CITY OF ALBUQUERQUE

RE: University Crossings (L-16/D36)
Engineers Certification for Release of Financial Guaranty
Engineers Stamp dated 2/6/06
Engineers Certification dated 2/21/07

**RE: Revised Grading Plan Approval for
University Crossings,
Albuquerque, New Mexico**

Re: University Crossings, Cactus Park
Grading and Drainage Plan
Engineer's Stamp dated 1-09-06 (L16-D36)

ROUGH GRADING APPROVAL		DATE
ENGINEER'S SEAL	UNIVERSITY CROSSING	DRAWN BY WCUJ
DAVID SOULE NEW MEXICO 14522 LICENSED PROFESSIONAL ENGINEER	GRADING AND DRAINAGE PLAN	DATE 2-02-06
	Rio Grande Engineering	SHEET # 1 OF 2
	1808 CENTRAL AVENUE SE SUITE 201 ALBUQUERQUE, NM 87106 (505) 872-0899	JOB # 2537

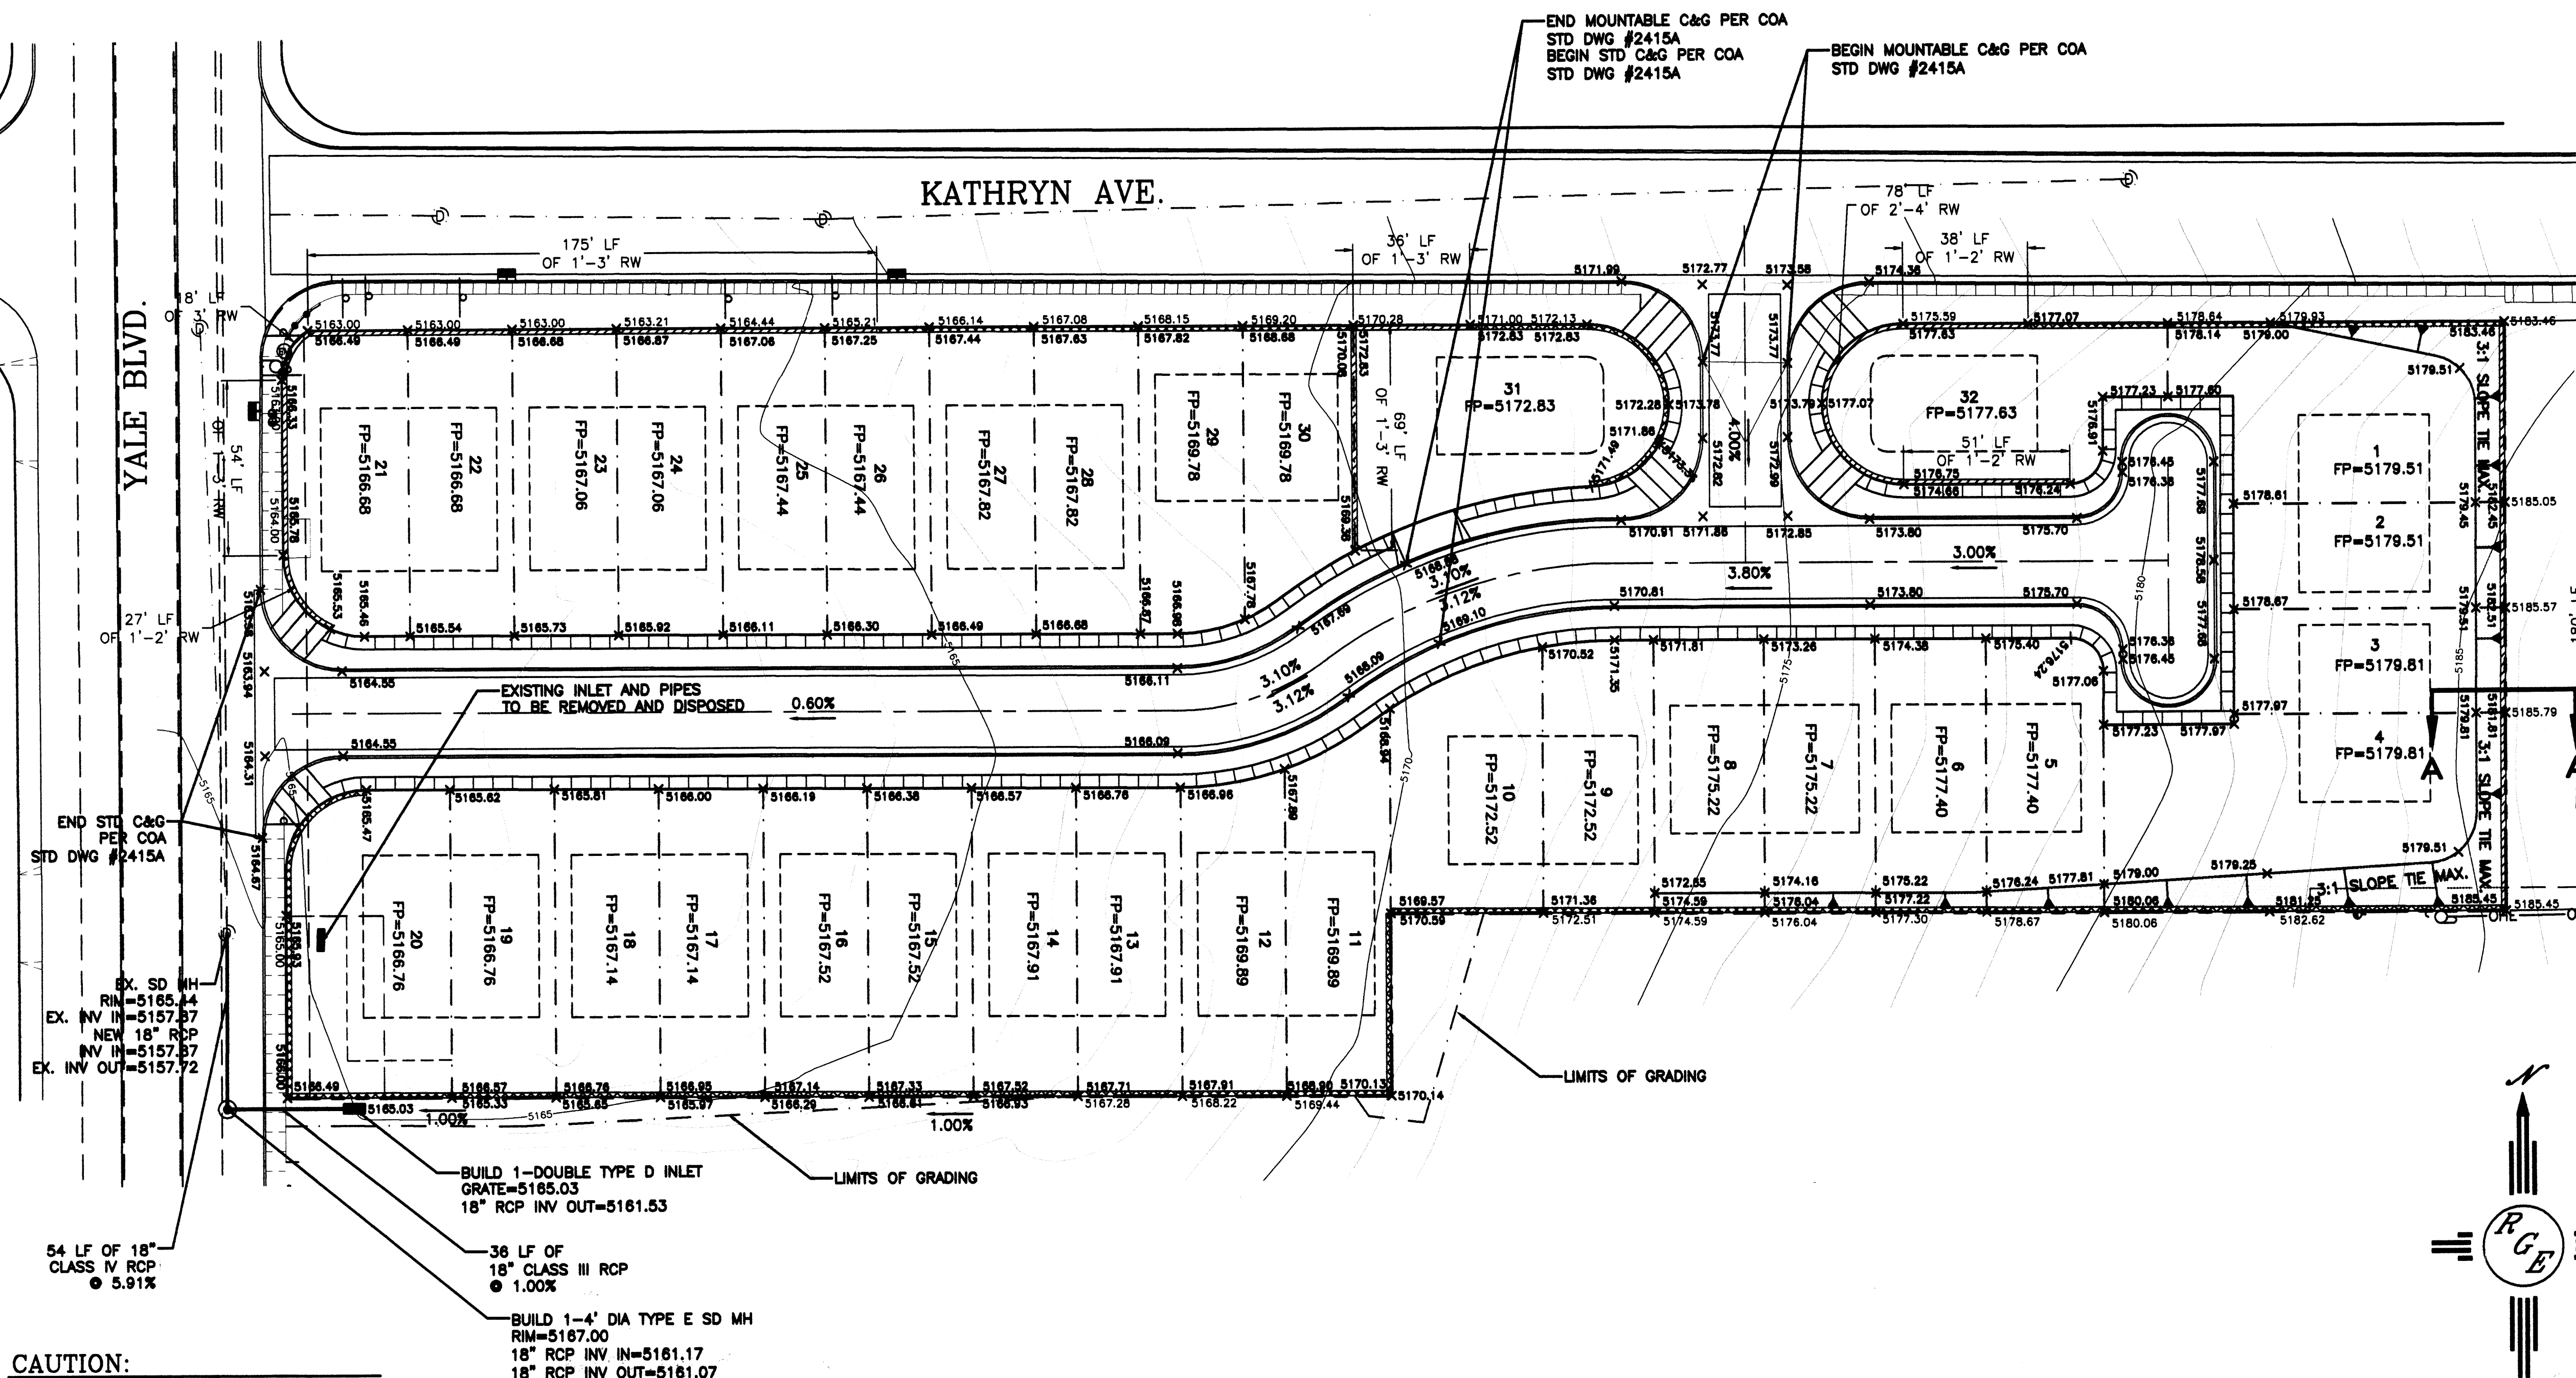
1. There is a possible ponding problem to the south of this site. How is this going to be addressed? Is a culvert or swale going to be placed between lots 10 & 11 or is permission being sought out to grade off site so this area may drain away from the inside corner around the outside corner?

2. The existing inlet located at the southwest corner, which is to remain, who is going to maintain it? Does it belong to the Park or to this subdivision?

The plan was revised to show minor grading on the adjacent City Park/ community Center. The adjacent property is native without any improvements within the proposed disturbed area. We are in the process of obtaining Parks and Recreations approval for this.

Based upon our informal conversation regarding this inlet, we have revised the plan to show the inlet outside of this development. The only flows going to the inlet will be from the undeveloped area of the City Park / Community Center. The new inlet location will lie within the existing drainage easement.

ENGINEER'S SEAL	UNIVERSITY CROSSING	DATE	DRAWN BY WCWJ
DAVID SOULE NEW MEXICO REGISTERED PROFESSIONAL ENGINEER 14522	GRADING AND DRAINAGE PLAN	12-30-05	DATE
	P.R.O. Grande Engineering	1006 CENTRAL AVENUE SE SUITE 201 ALBUQUERQUE, NM 87106 (505) 872-0999	SHEET # 1 OF 2
			JOB # 2537

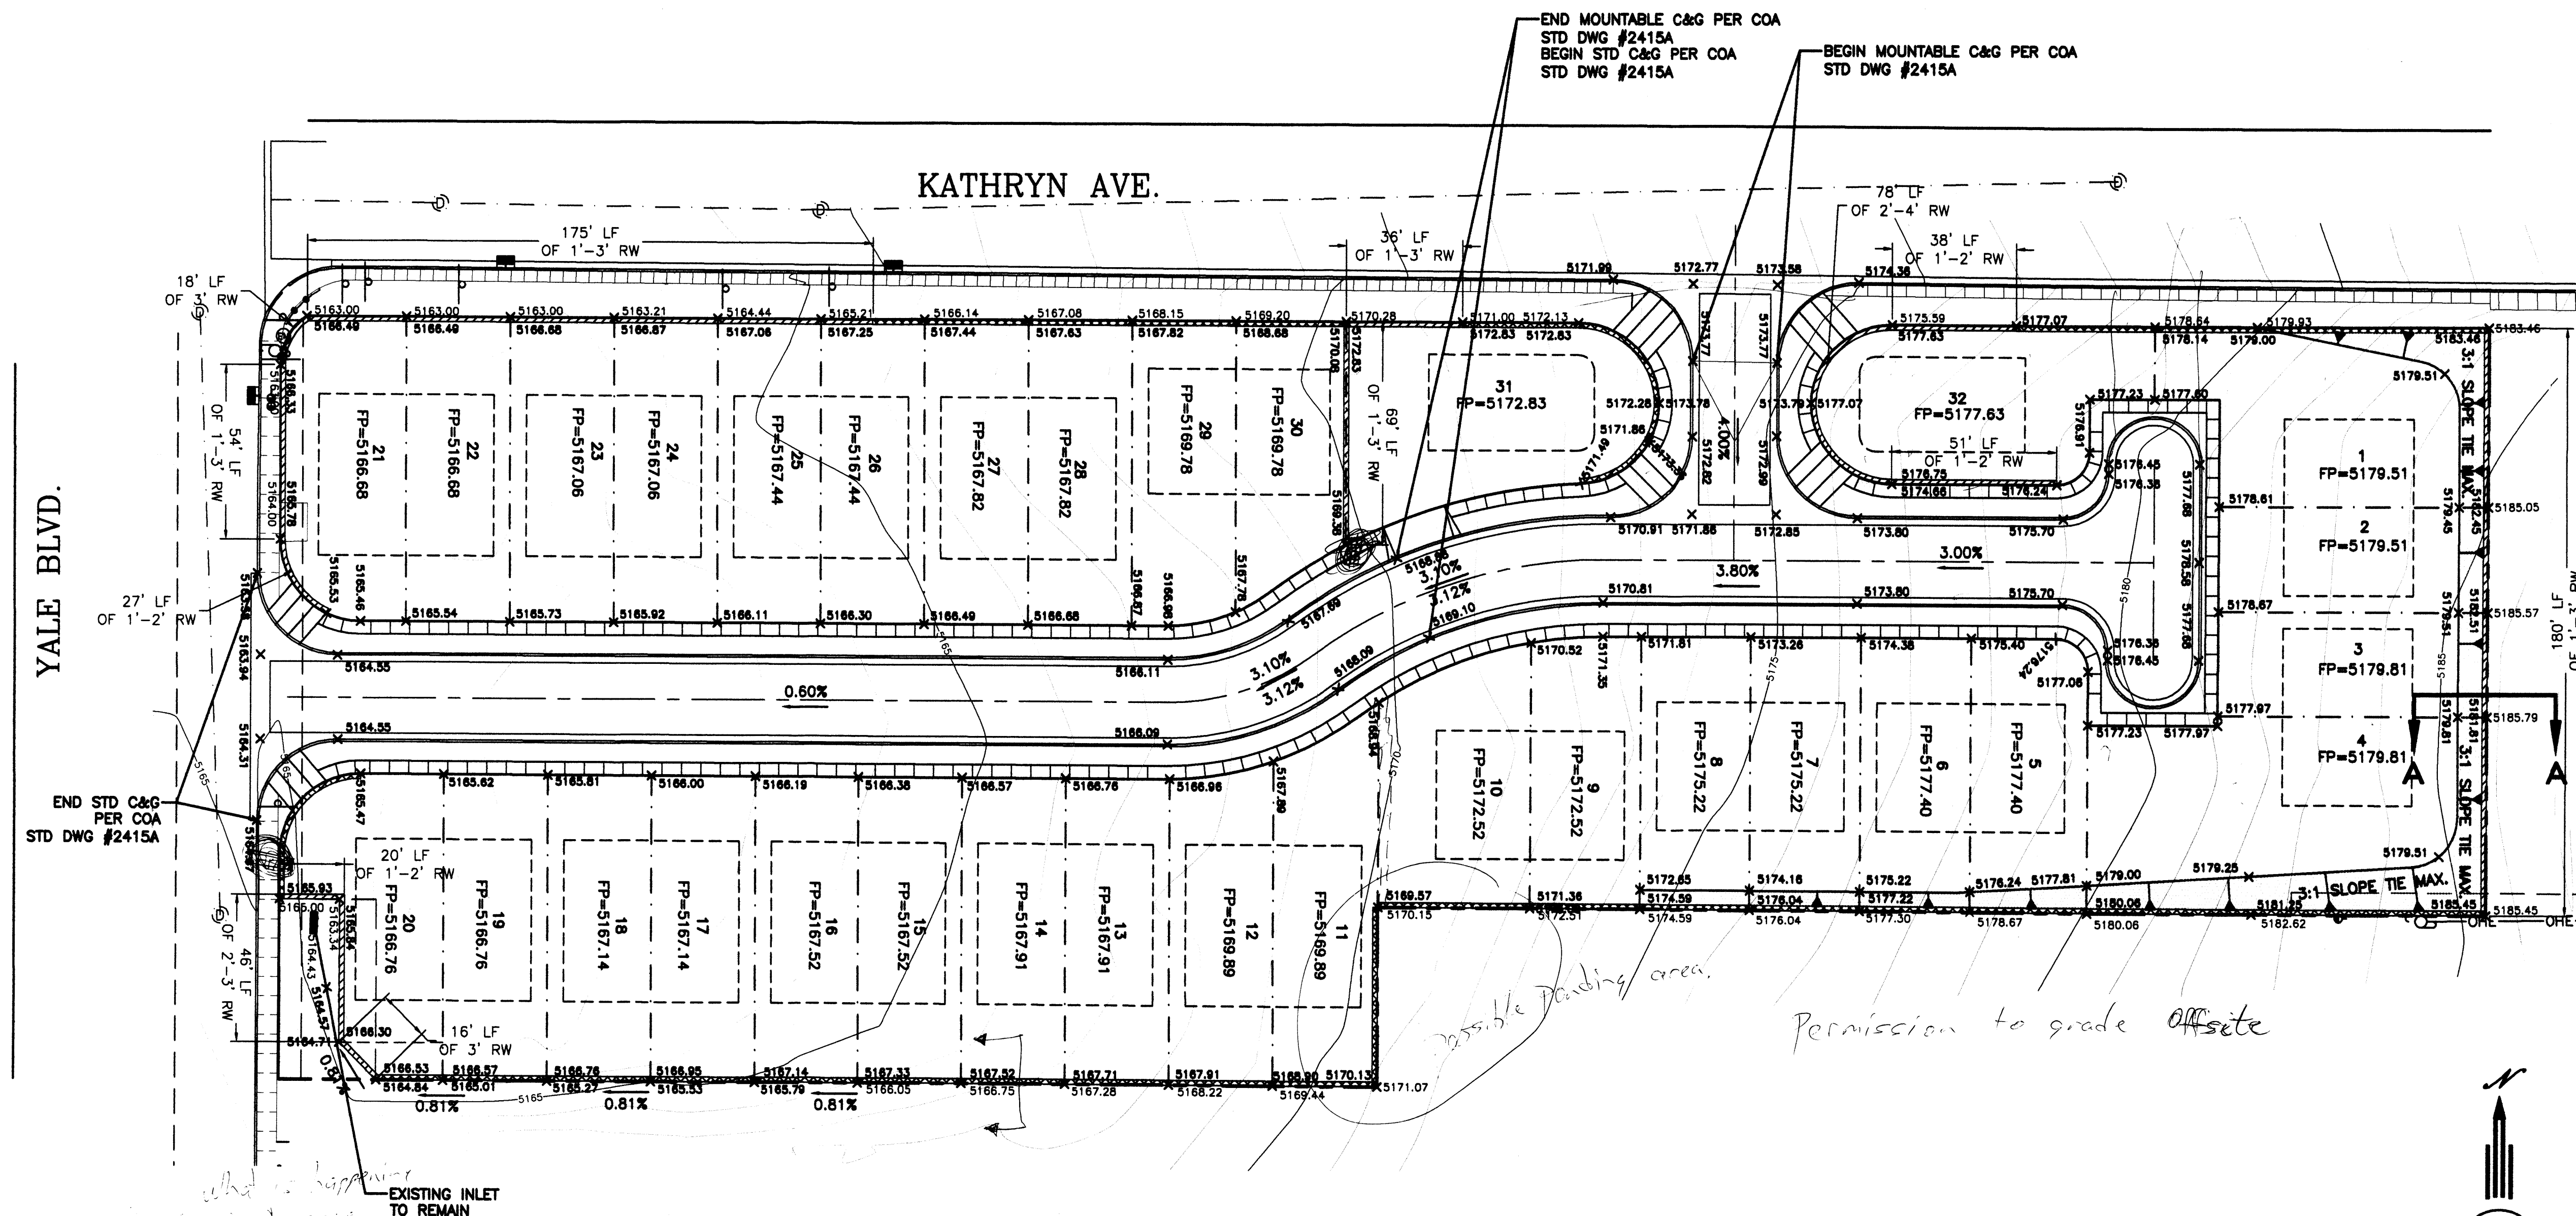
1. There is a possible ponding problem to the south of this site. How is this going to be addressed? Is a culvert or swale going to be placed between lots 10 & 11 or is permission being sought out to grade off site so this area may drain away from the inside corner around the outside corner?
2. The existing inlet located at the southwest corner, which is to remain, who is going to maintain it? Does it belong to the Park or to this subdivision?
